EPC STORMWATER REVIEW COMMENTS
 IN ORANGE BOXES WITH BLACK TEXT

EL PASO COUNTY GRADING AND EROSION CONTROL PLAN CHECKLIST

EPC Project Number: 241

GRADING & EROSION CONTROL PLAN NOTES:

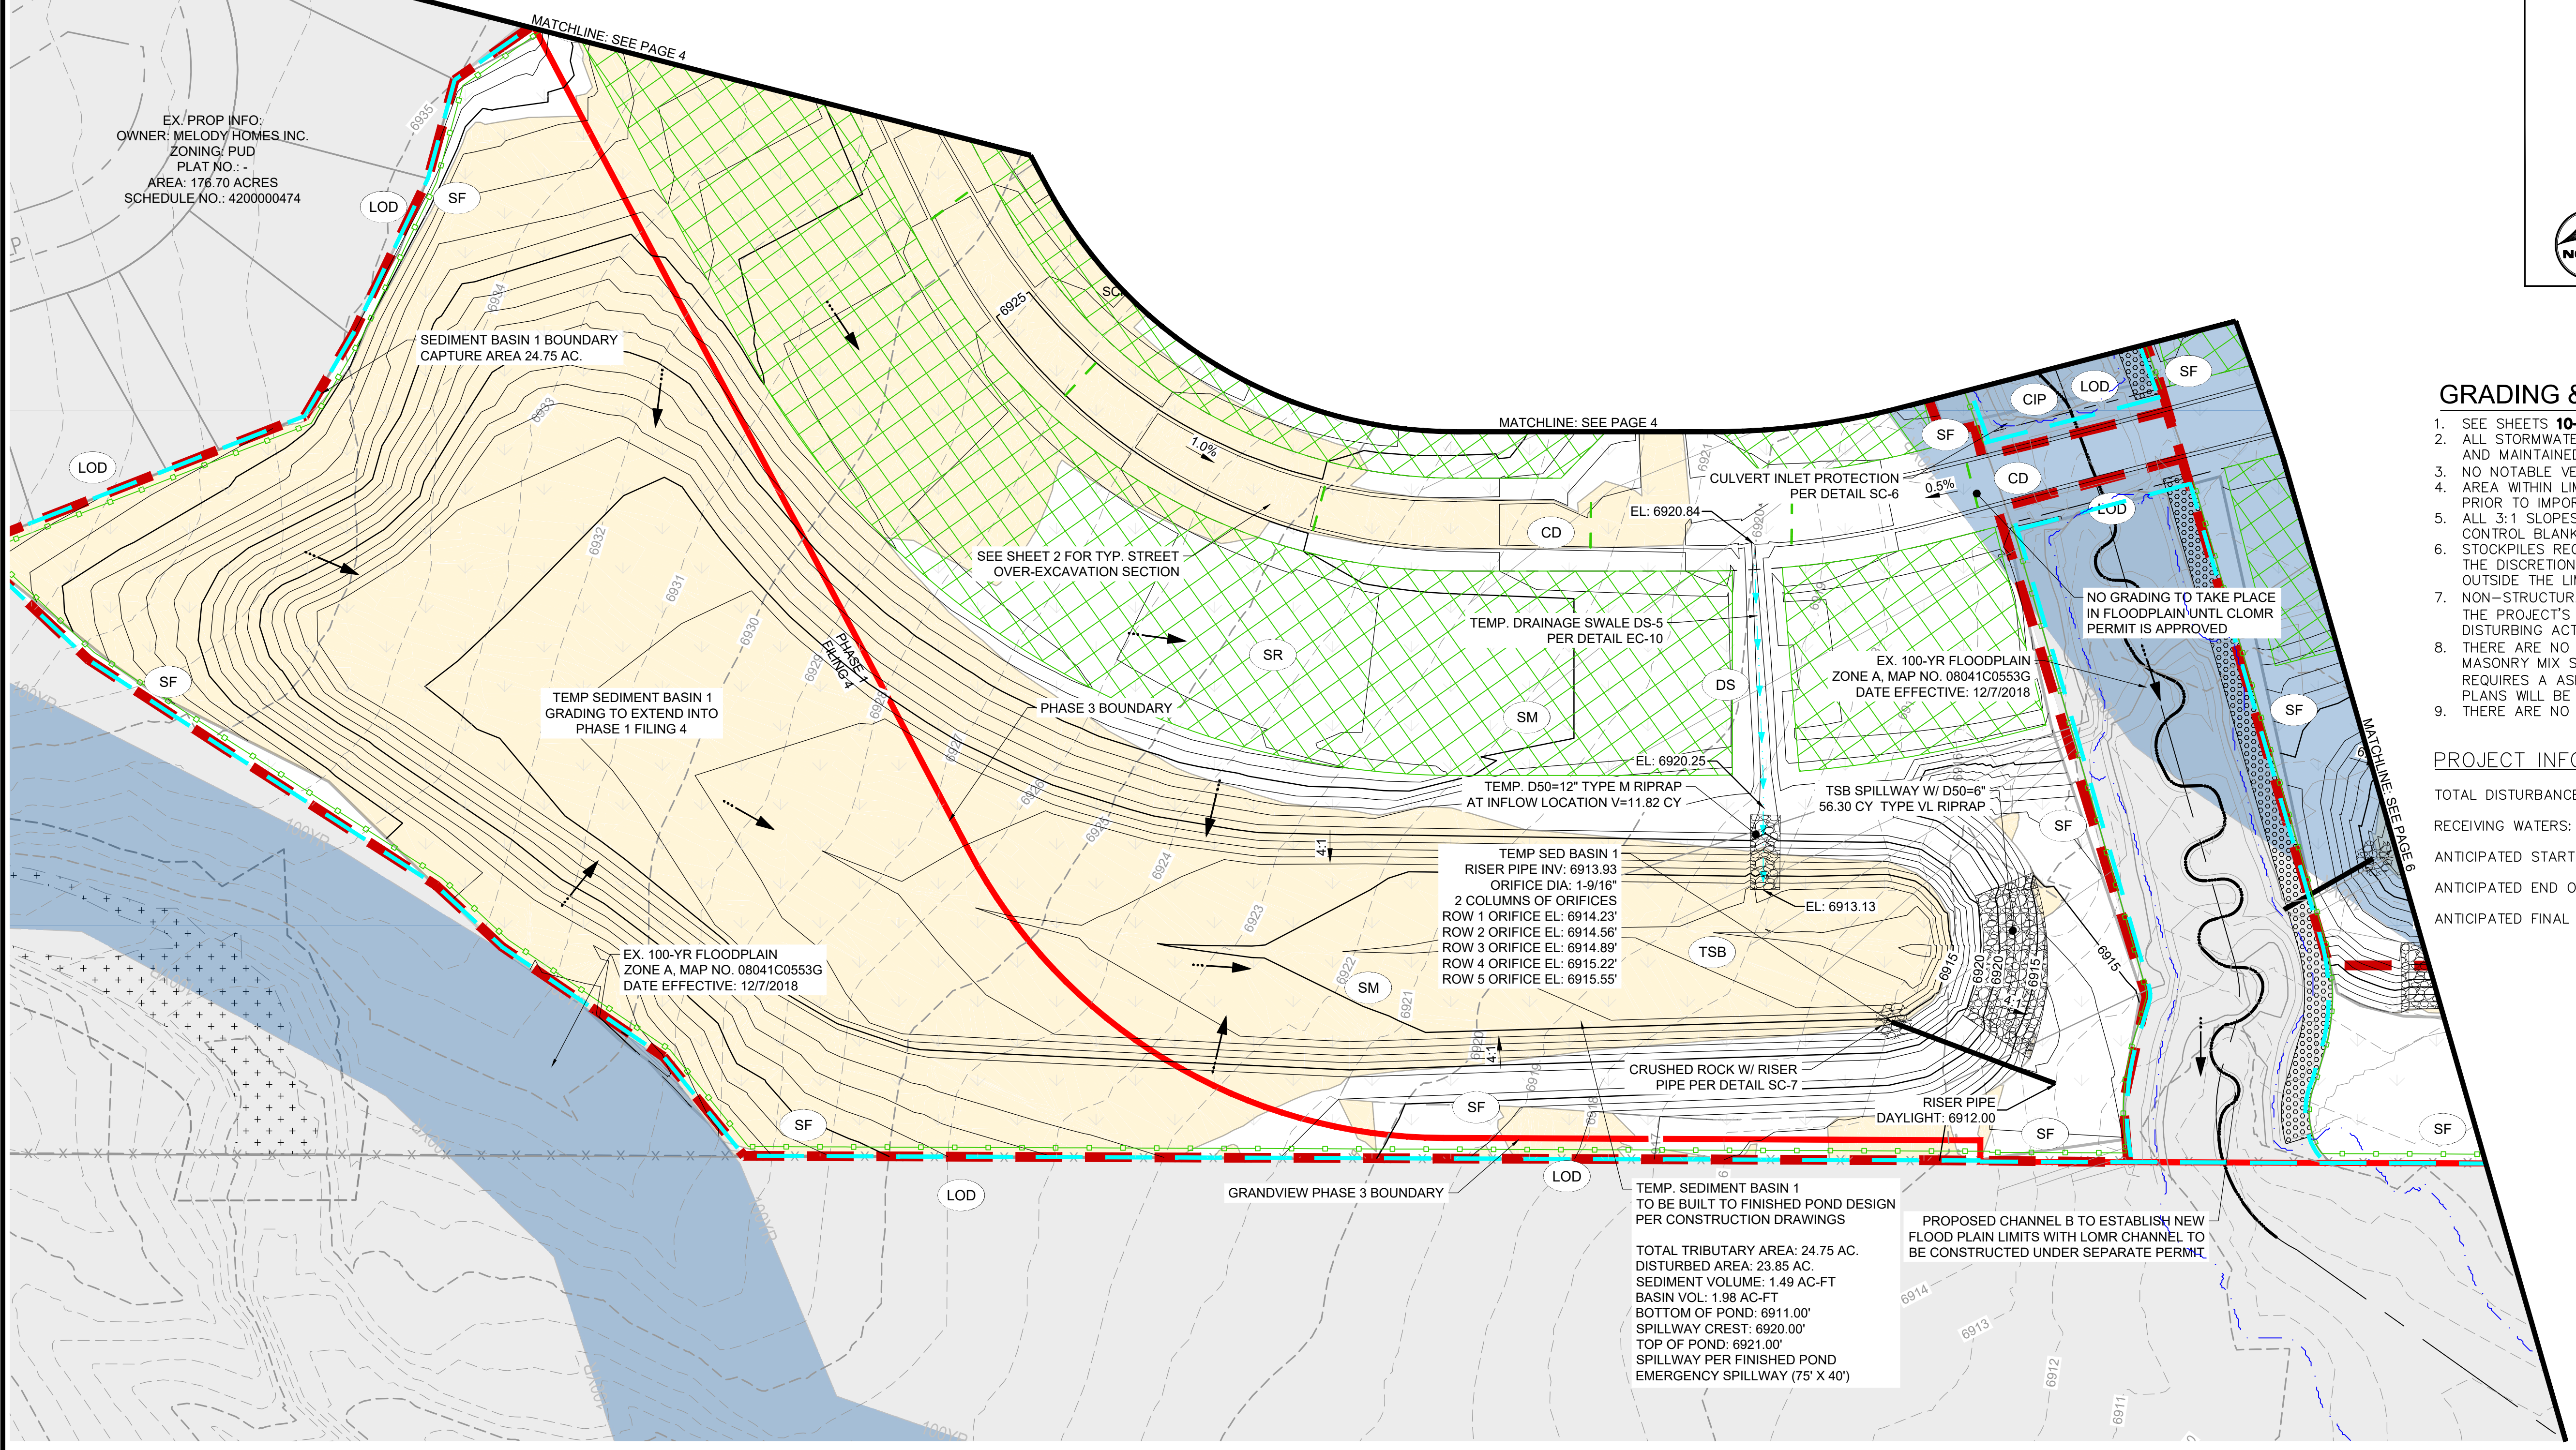
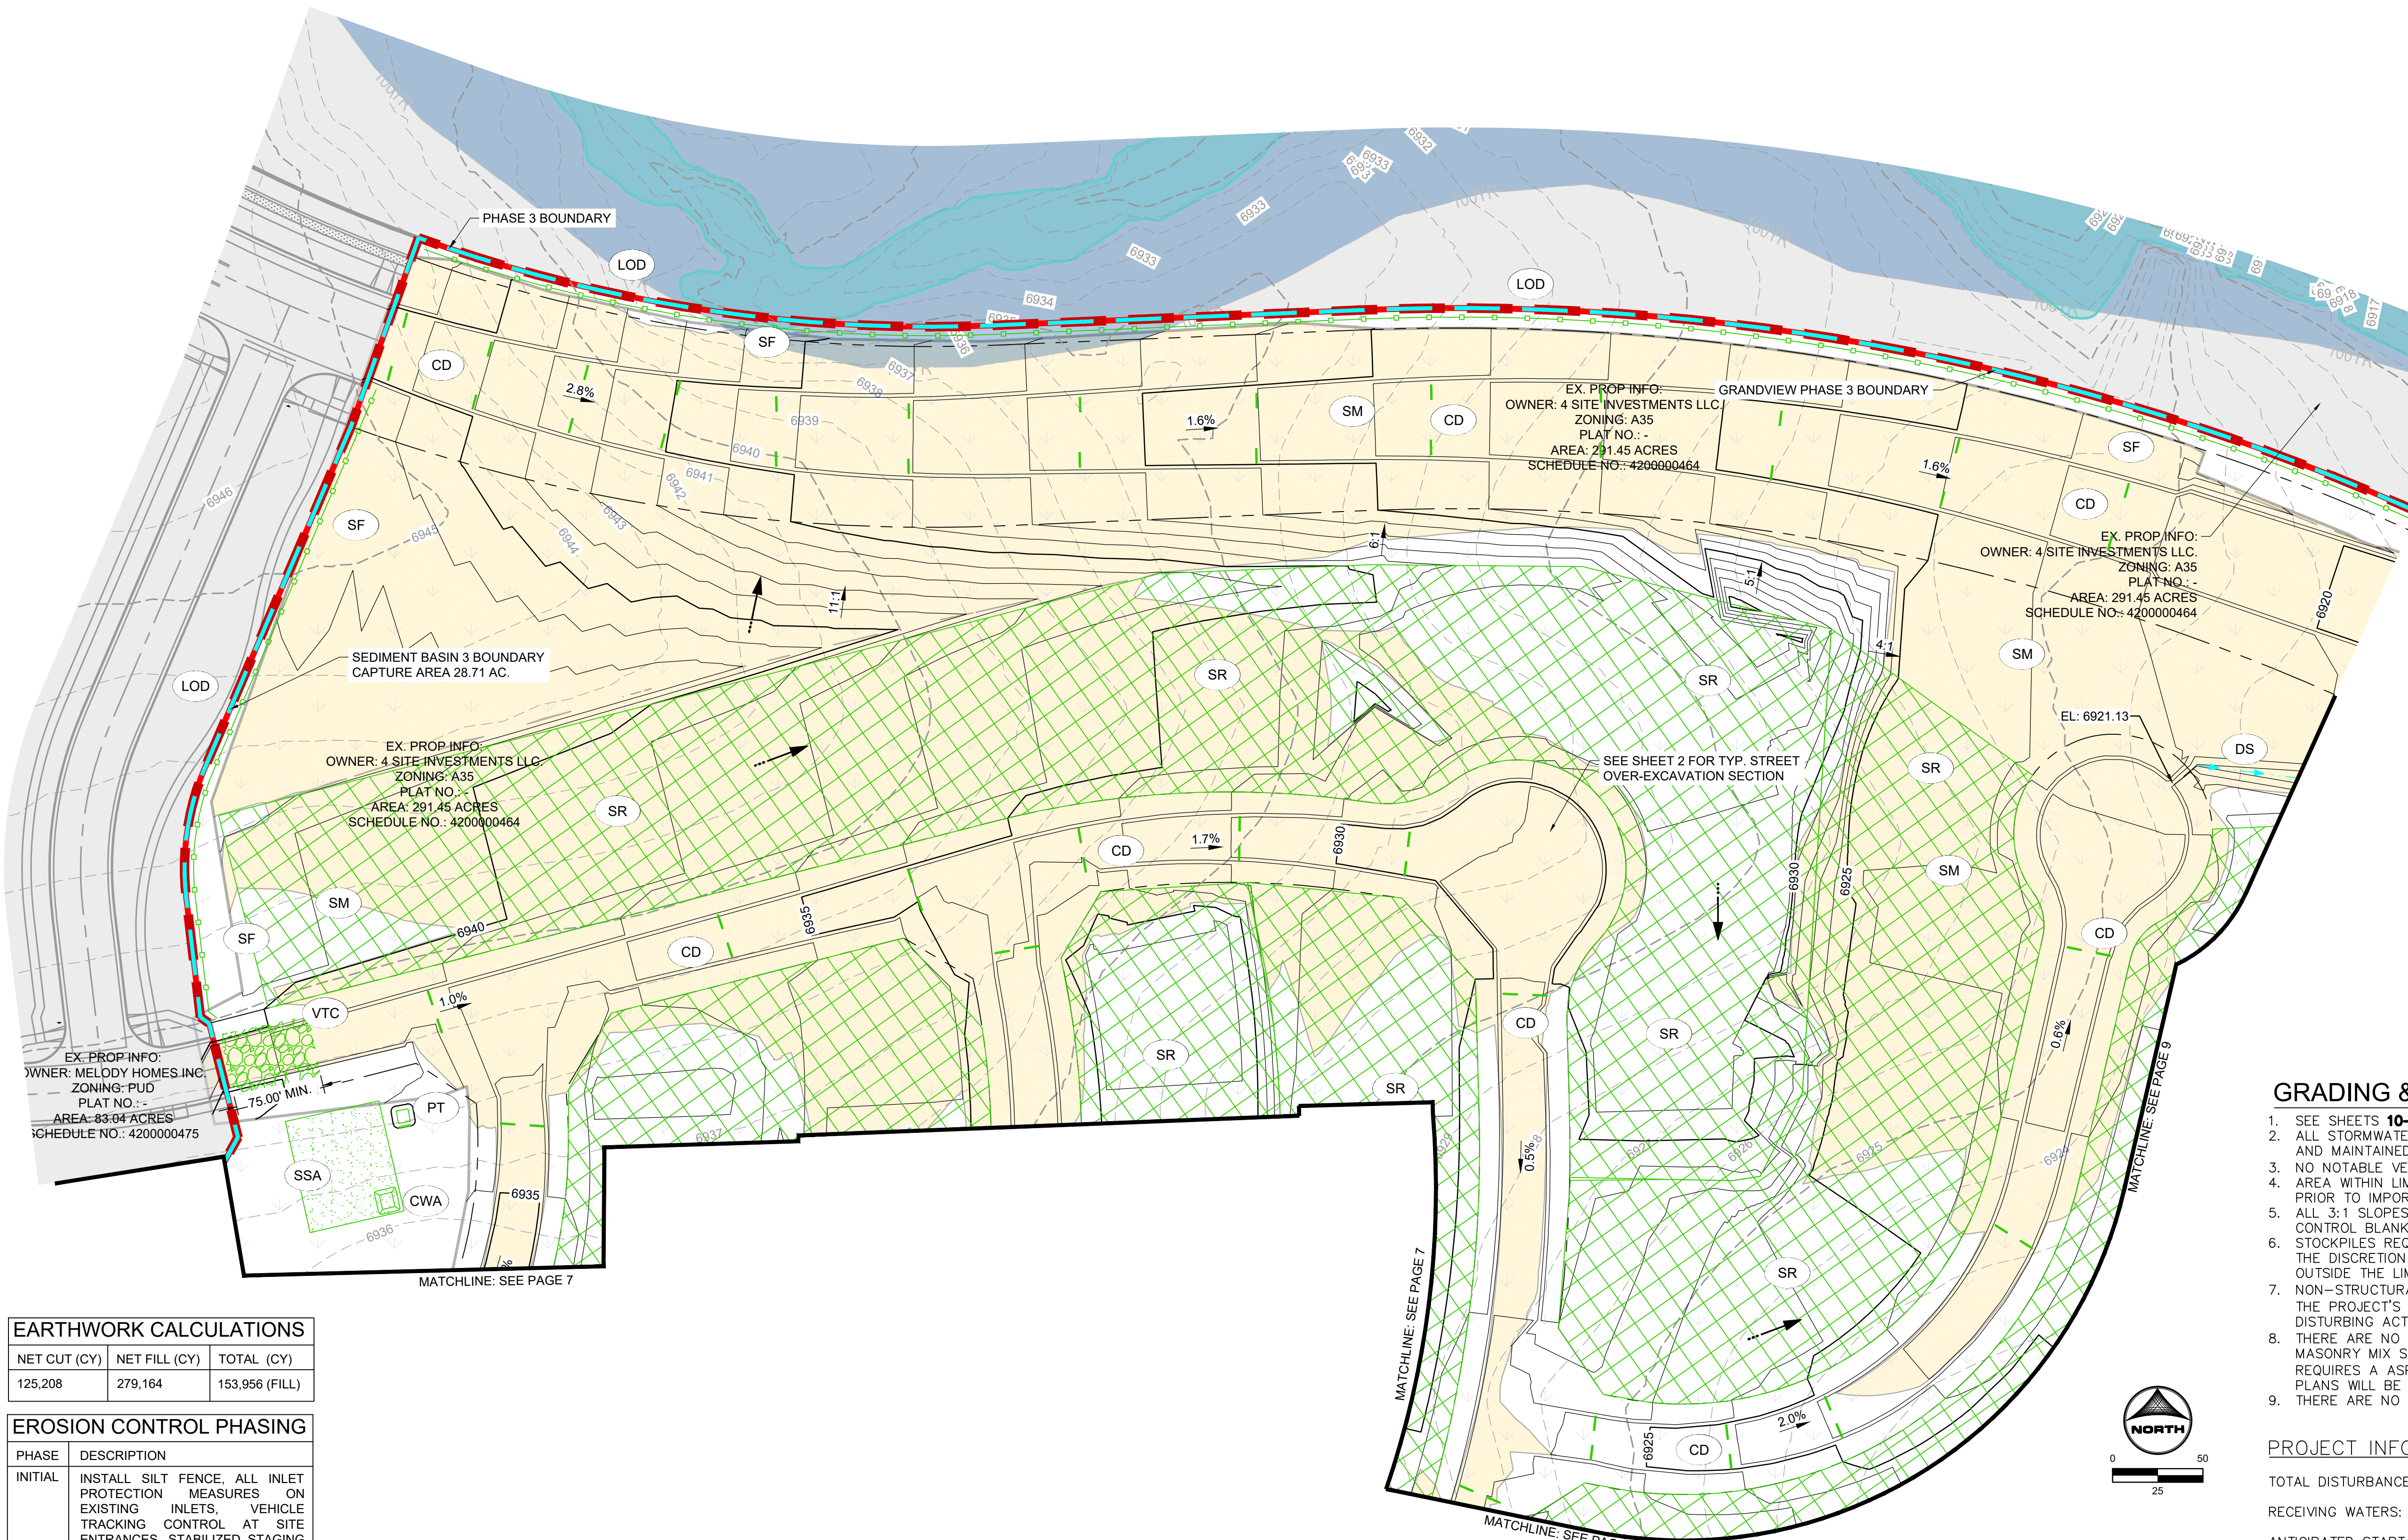
v	All proposed temporary construction control measures, structural and non-structural. Temporary construction control measures shall be identified by phase of implementation to include "initial," "interim," and "final" or shown on separate phased maps identifying each phase		N
w	Vehicle tracking provided at all construction entrances/exits. Construction fencing, barricades, and/or signage provided at access points not to be used for construction		Y
x	Temporary sediment ponds provided for disturbed drainage areas greater than 1 acre		Y
